State of Washington
DEPARTMENT OF FISH AND WILDLIFE

SUBJECT: WDFW COMMENTS ON DV-24-00001

Thank you for the opportunity to comment on DV-24-00001 concerning the request for a development agreement for 30 years from the approval date for Swauk Creek Planned Unit Development (z-06-27). Washington Department of Fish and Wildlife (WDFW) has reviewed the application and supporting documents. Our comments are regarding the project's impact on priority fish and wildlife habitats, particularly the riparian habitat of Swauk Creek and its associated floodplain. Specifically, our comments are to ensure that if the application is approved that the development will not result in loss of Fish and Wildlife Habitat Conservation Areas (FWHCA) under Kittitas County Critical Areas Ordinance (CAO).

P.U.D. Master Site Plan

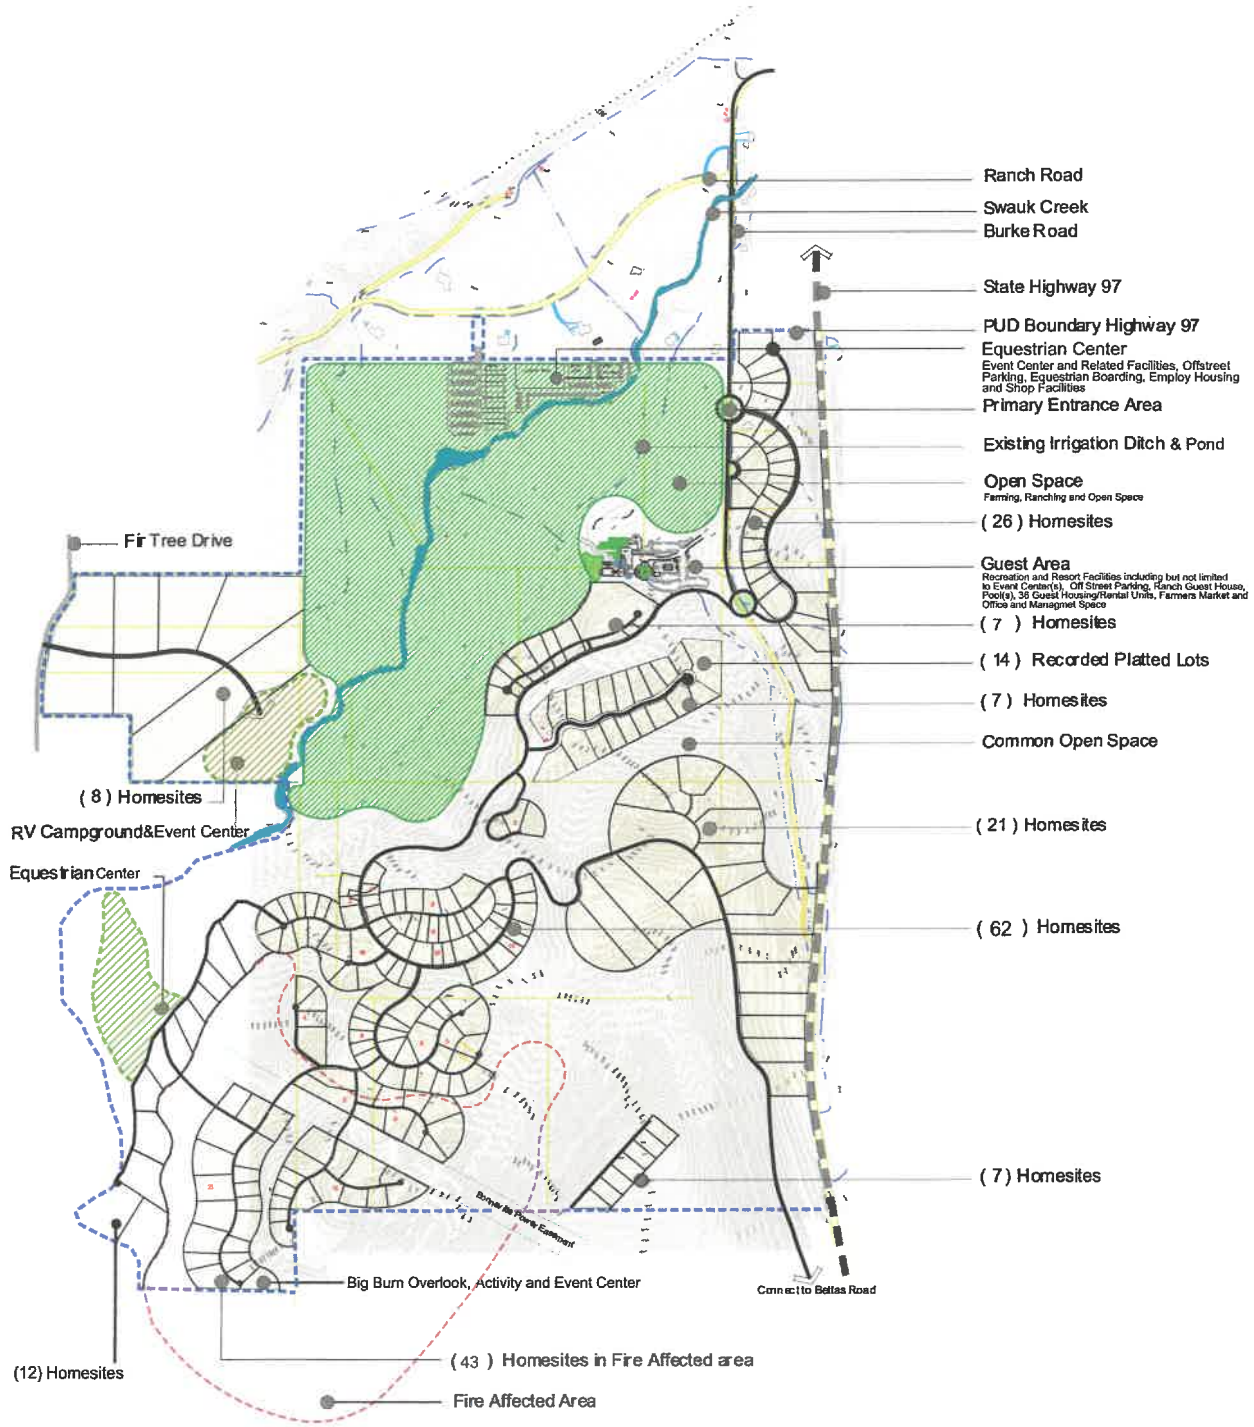
The Master Site Plan, submitted as part of the review, shows recreational elements potentially in both the riparian area and floodplain. These elements may contain some passive recreation, but various infrastructure elements are listed, including campgrounds, event centers, parking, equestrian boarding, employee housing, and shop facilities. These activities are likely to have impacts to the riparian area and floodplain of Swauk Creek through either vegetation removal and/or prevention of future riparian and floodplain vegetation recruitment. Swauk Creek is a critical stream to various fish and wildlife species and is one of the primary streams identified in the Yakima Steelhead Recovery Plan (YBFWRB 2009). Streamside recreation and increased development in the riparian area and floodplain are both called out under limiting factors in the plan.

While the original site plan was authorized under a previous Critical Areas Ordinance (CAO) and Shoreline Management Plan (SMP), those previous standards do not meet the current standards of Best Available Science, nor are consistent with the current CAO and SMP. Under the current CAO, Swauk Creek is a fish-bearing stream within the Cascade Ecoregion and within the jurisdiction of the Kittitas County SMP. The Riparian Management Zone (RMZ) is defined here under Kittitas County Critical Areas Code as 150 foot.

WDFW requests that if the development agreement is extended, as is proposed, that all development activities within the SMP and CAO riparian areas and floodplains be held to the current CAO and SMP standards. Both the CAO and SMP standards are to ensure no net loss of

habitat within both riparian area of Swauk Creek and its associated floodplain. WDFW would recommend placing all recreation infrastructure elements outside of the RMZ and floodplain. If some elements cannot be placed outside of the RMZ and floodplain, then WDFW recommends a discussion between the applicant, the county, WDFW and WA Dept of Ecology (as they administer the SMP). This meeting would be to discuss potential impacts from these developments and ways to minimize their impact and eventually mitigate for those impacts that cannot be avoided.

The riparian area and floodplain of Swauk Creek shall be defined according to current CAO and SMP standards at the time of development. All recreation infrastructure shall be located outside of the riparian and floodplain area of Swauk Creek. Any vegetation removal must follow current CAO standards. If any infrastructure is placed in the riparian or floodplain area, the applicant will consult with the Departments of Ecology and Fish and Wildlife in addition to the county to discuss impacts and measures to mitigate impacts.
